Design Studies
SDRP Design Response

PLC Greyhouse Precinct
12 October 2021 R.4

PROJECT: Pymble Ladies College
RE: State Design Review Panel (SDRP) – Review 1, 18 August 2021

6 SHADOW DIAGRAM PROPOSED June 21 - 12 30PM
1 : 1000

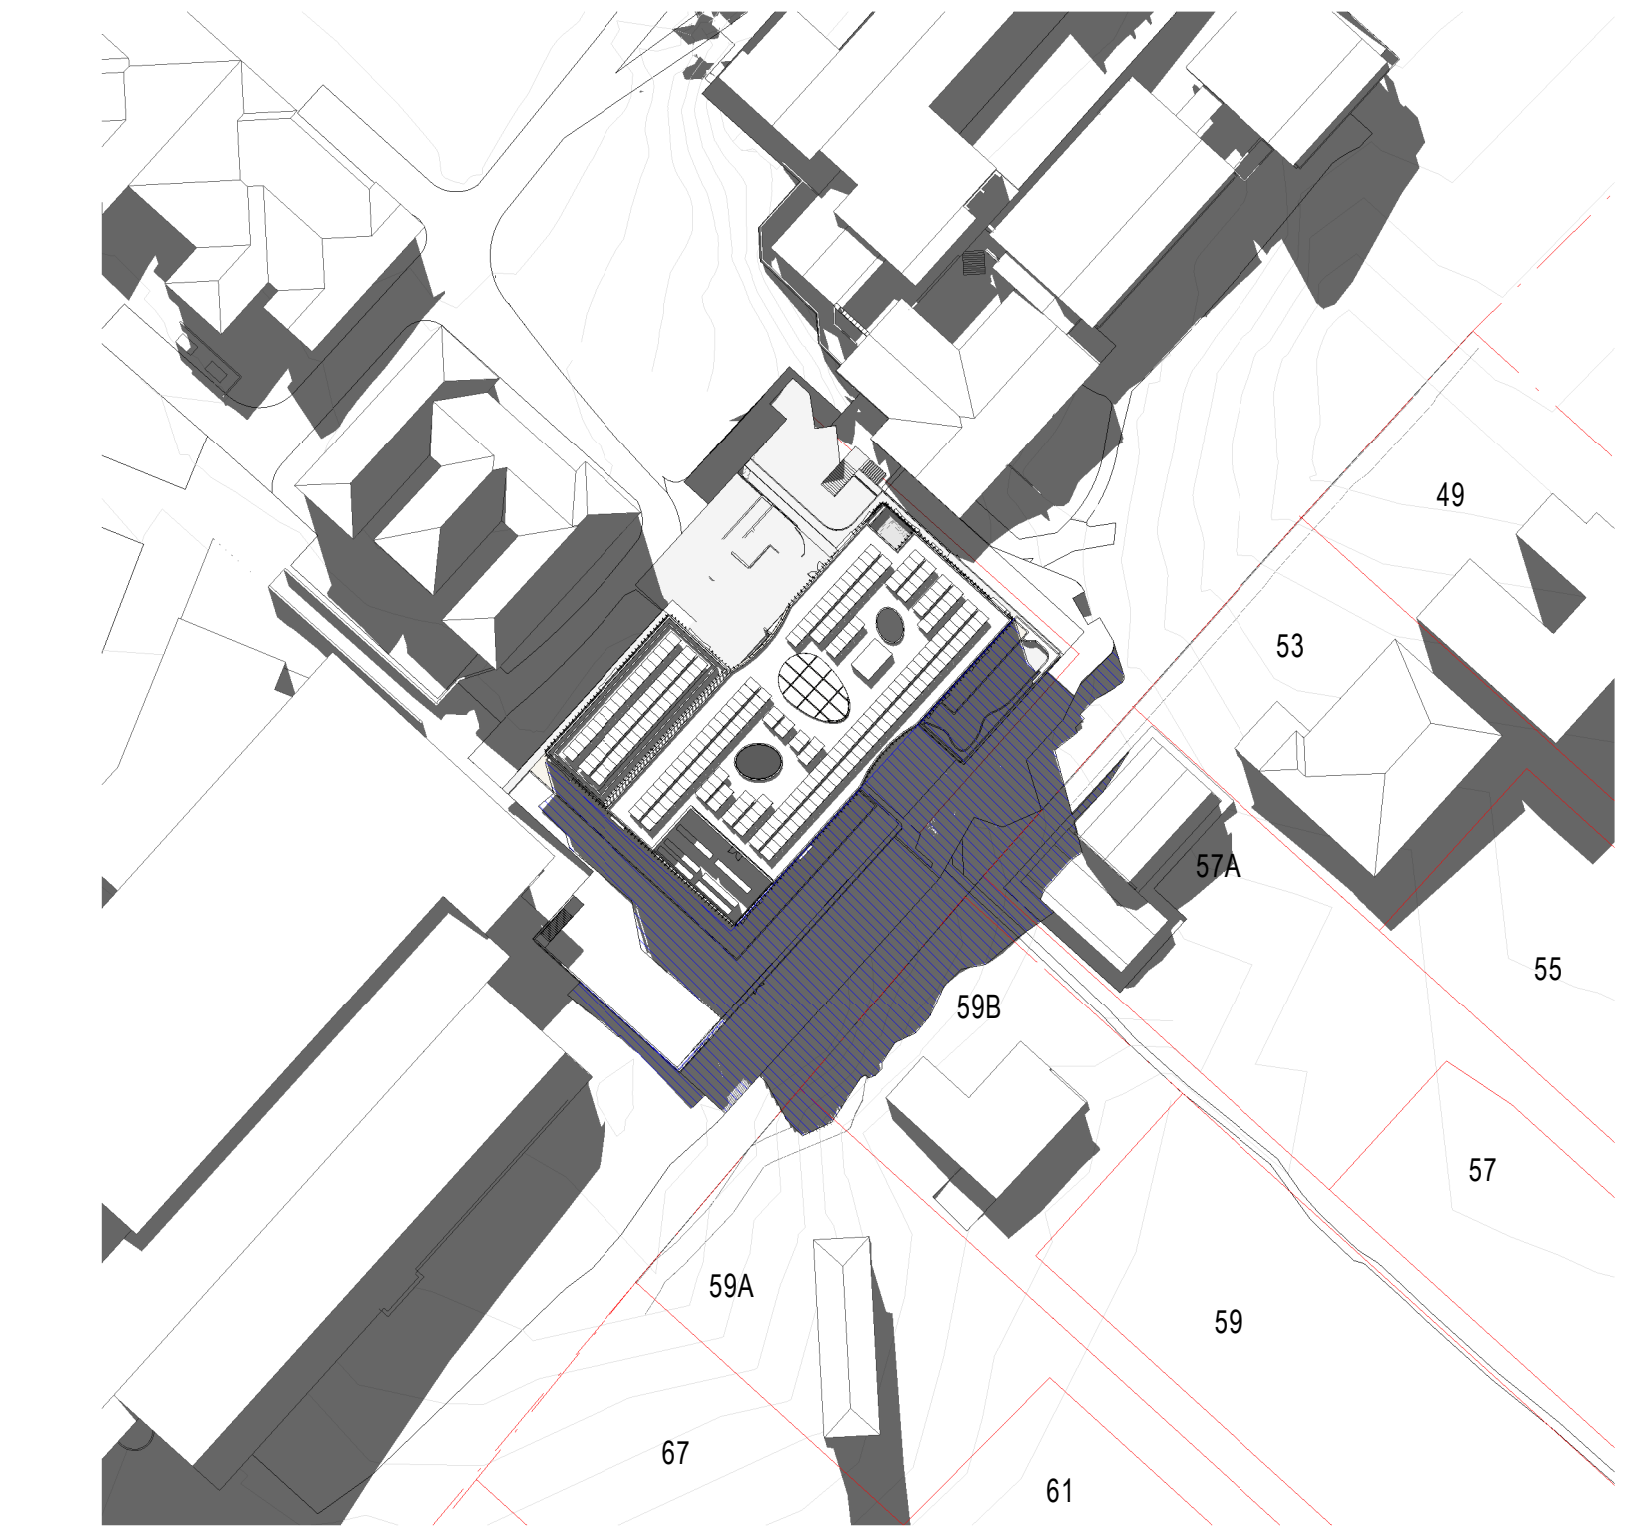
9. Review if the overshadowing of neighbours on Pymble Ave can be minimised through changes to the corners and edge of the building. Review the northern end of the new building and consider reducing the bulk and form to increase sunlight.
10. Re-examine the translation of the built form from sketch design to final design. Consider whether the architectural elegance has been lost in the formalisation and increase in scale of the building.

Shadow encroachment – from 11.59am (+4 min)

Shadow encroachment – from 12.04pm (+9 min)

Shadow encroachment – from 12.15pm (+20 min)
